Our Case Number: ABP-319866-24

Re: Proposed development known as North Irish Sea Array ("NISA") Offshore Wind Farm
Located off the coast of Counties Dublin, Meath and Louth (www.northirishsearraysid.ie)

Planning Observation

ABP. Ref. OA29N.319866
Applicant North Irish Sea Array Windfarm Ltd.
Address The offshore infrastructure of the proposed development will be located off the coast of counties Dublin, Meath and Louth. The onshore infrastructure of the proposed development will be located in County Dublin (Fingal County Council and Dublin City Council administrative areas).
Proposal Summary The proposed development is an offshore wind farm comprising of both offshore and onshore infrastructure. The proposed development boundary, within which the proposed development is located, will include offshore infrastructure off the coast of Counties Dublin, Meath and Louth and onshore infrastructure within County Dublin (Fingal and Dublin City Council administrative areas).

Image 7.3 Proposed grid facility which comprises the Compensation Substation and Bremore 220kV GIS Substation.

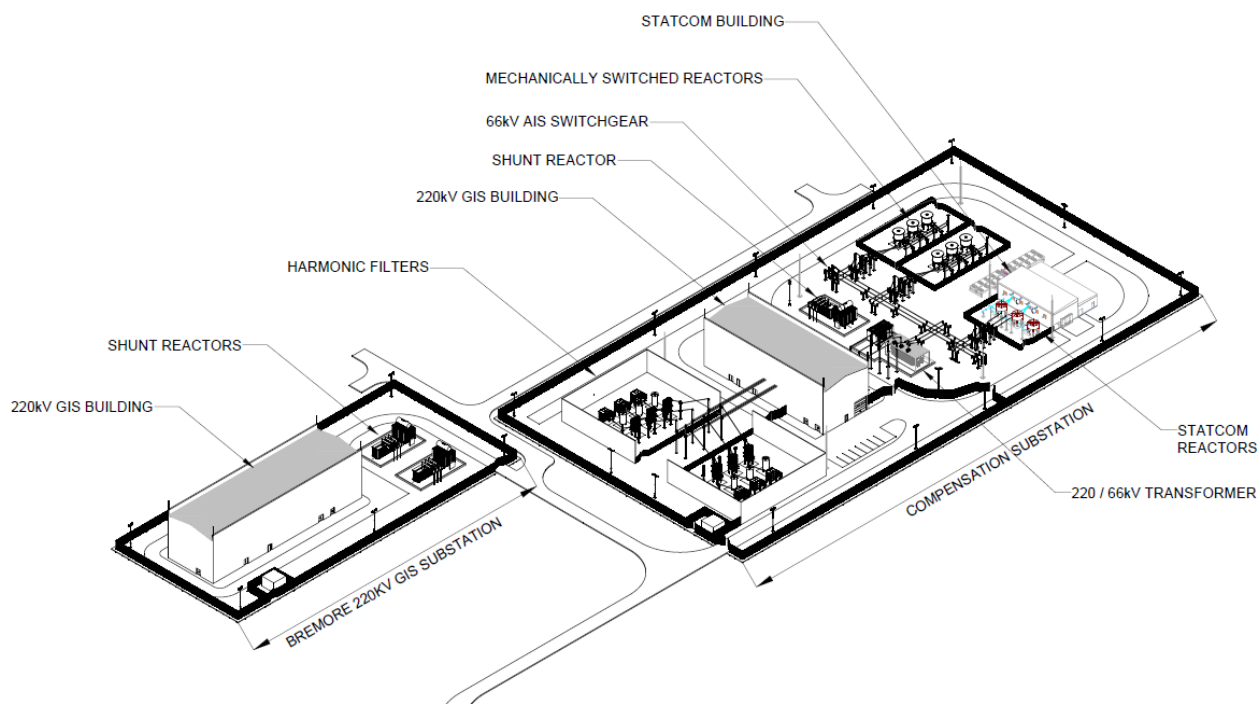
We would note that the Flemington LAP lands to the south are earmarked for future residential development and this will become more apparent following the publication of the Draft LAP by Fingal County Council in September of this year. The proposed substation building, shown above, comprising what appears to be a minimum building height of approximately 17 metres, will have a significantly negative effect on the future development of our clients lands and indeed, the wider LAP landbank, which our client's consider will severely impact their landholdings from a visual and valuation perspective.

In addition to the above, we would also note following initial stakeholder consultation with Fingal County Council in relation to the Flemington LAP and upon review of the Draft development layout presented for the lands, which will be published as part of same, there is a link road proposed along the northern boundary of the LAP landbank and the Planning Authority have made very clear that this piece of infrastructure will be critical to the overall delivery of development on the lands. This proposed link road is located to the immediate south of the substation access road, which is proposed in the drawing extract above, and we consider that a more suitable approach rather than providing two roads at this location running parallel to one another, would be the consideration of a joint up approach between the substation site above and the LAP lands, as opposed to doubling up on road infrastructure at this location. Upon our review it would appear feasible that a spur road off the main access road to the substation could be facilitated which provides connectivity to and permeability

between the LAP lands and the substation lands. Furthermore, it is noted that should the substation access road proposed above, and the LAP link road in its current position as proposed by FCC, will result in two accesses onto the adjacent R132 road, which we feel would present a traffic safety issue.
